**ROYAL PRINCE ALFRED HOPITAL
MULTI STOREY STAFF CAR PARK
CAMPERDOWN**

ACCESS REVIEW

Morris Goding Accessibility Consulting

9 May 2016

**LEVEL 0 GENERAL ARRANGEMENT PLAN**

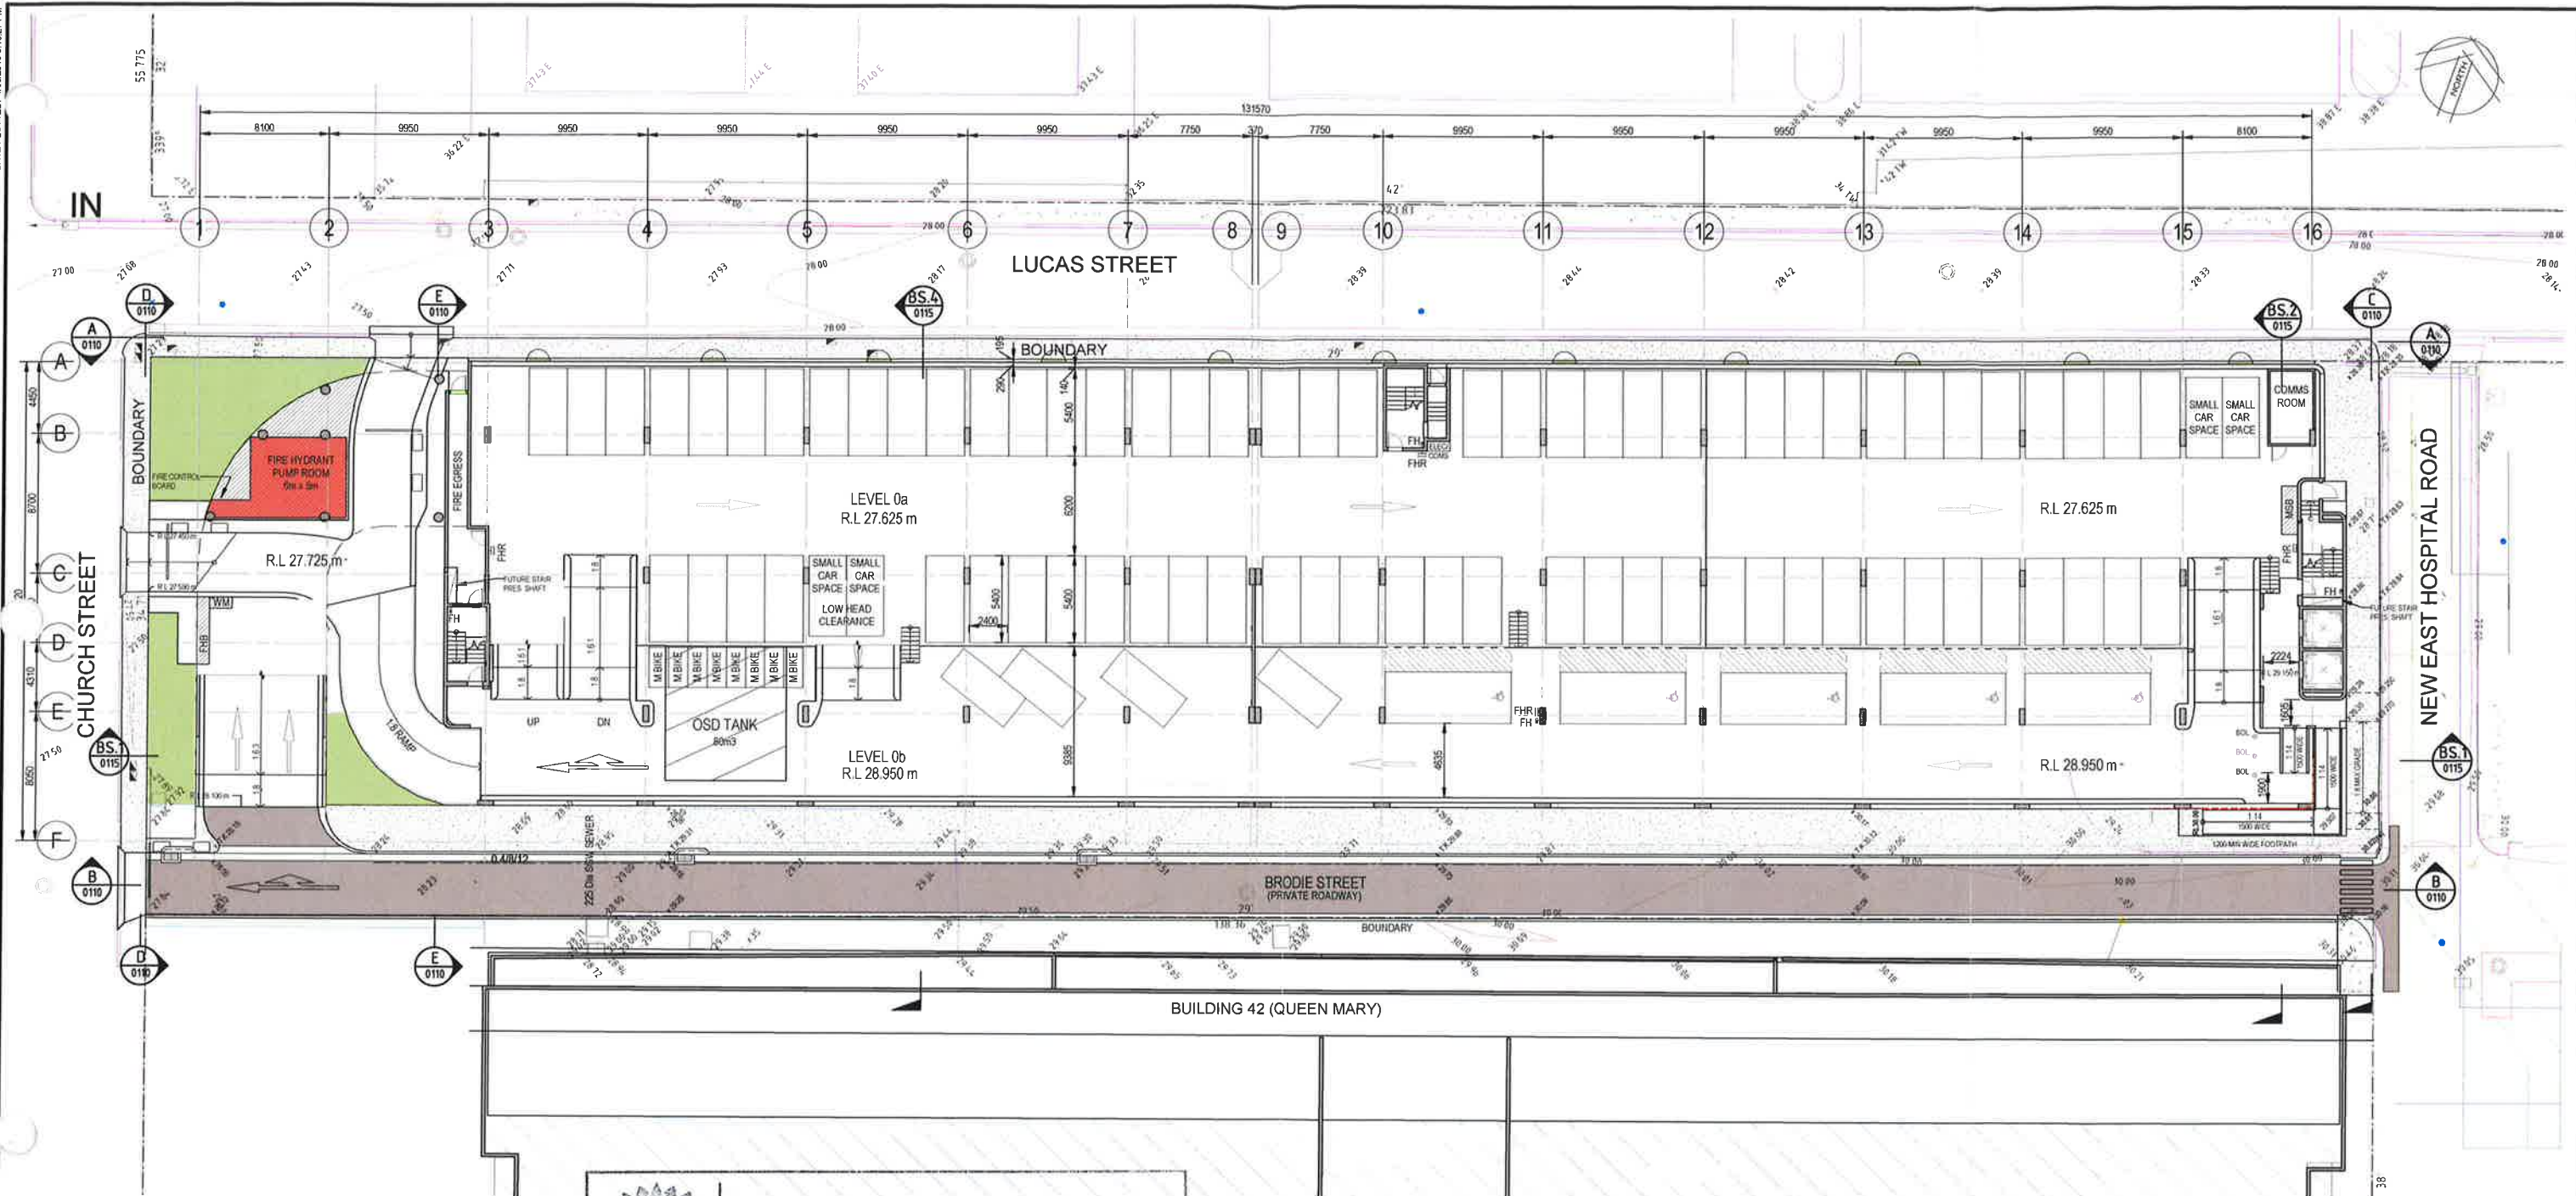
On level 0b, the path of travel from the accessible car parking spaces to the lifts and main entrance utilises the vehicle way. This is essentially level and greater than 1800mm wide. There is a kerb indicated near to the main entrance and the lift foyer.

- (i) Ensure an accessible path of travel from accessible car parks to lift lobby and building entrance.

The above recommendation is achievable and will be incorporated at construction certificate stage.
